Permit Inspections

Permit Number: ERES2502-0011

Description: Install 26 roof mounted solar panels.

Site Address: 15 PAPER BIRCH WAY

**PV-4**

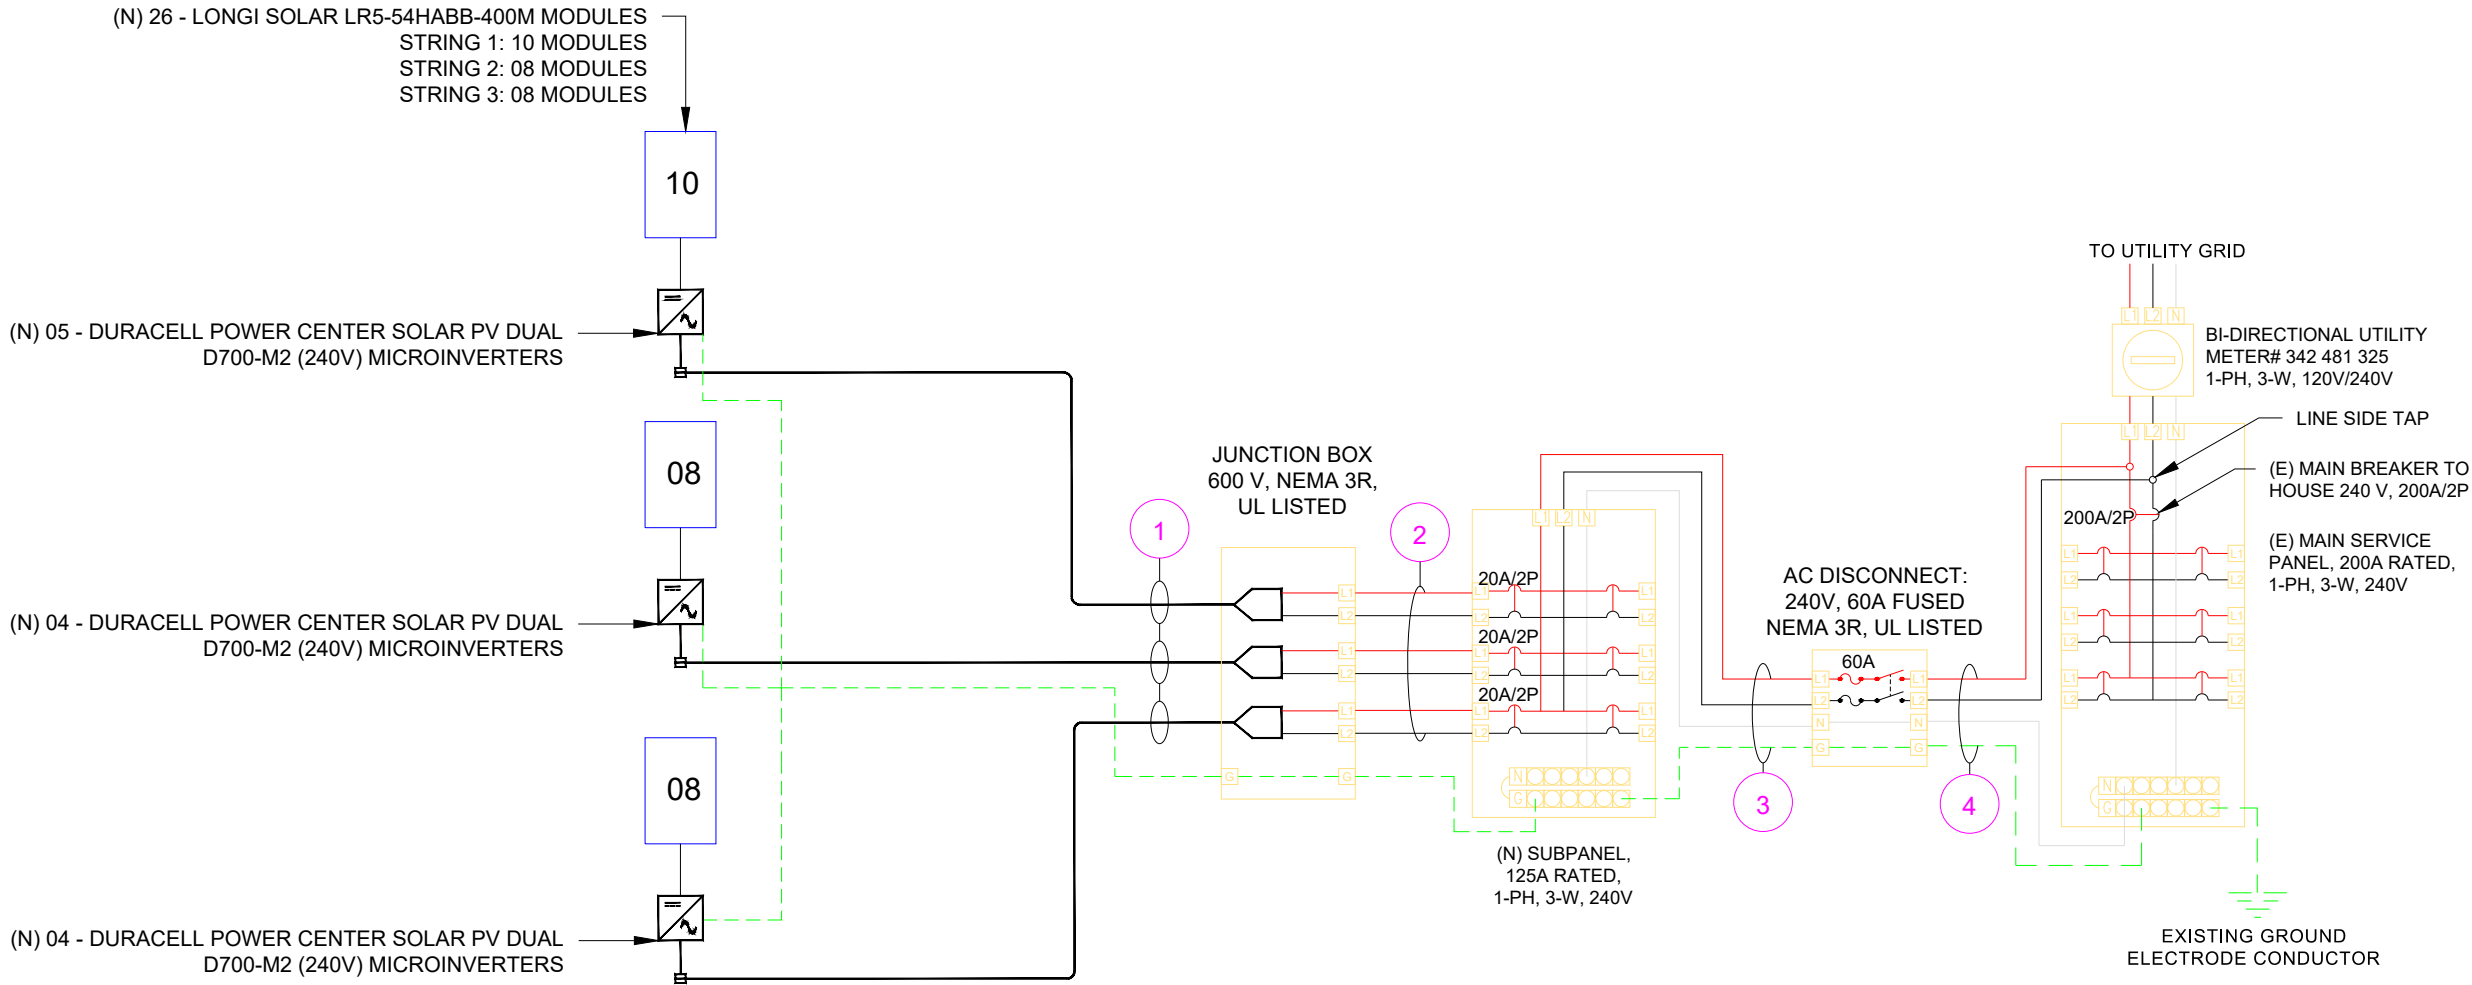
Plan that was approved at permitting on 5/12/25 shows conductors for number 3 and 4 circuits to be #6 gauge but #8 was installed. The original plan that was rejected on 2/10/25 at permitting showed it as #8 gauge. I advised homeowner that she would not have to be home for the reinspection because items needing addressed are outside.
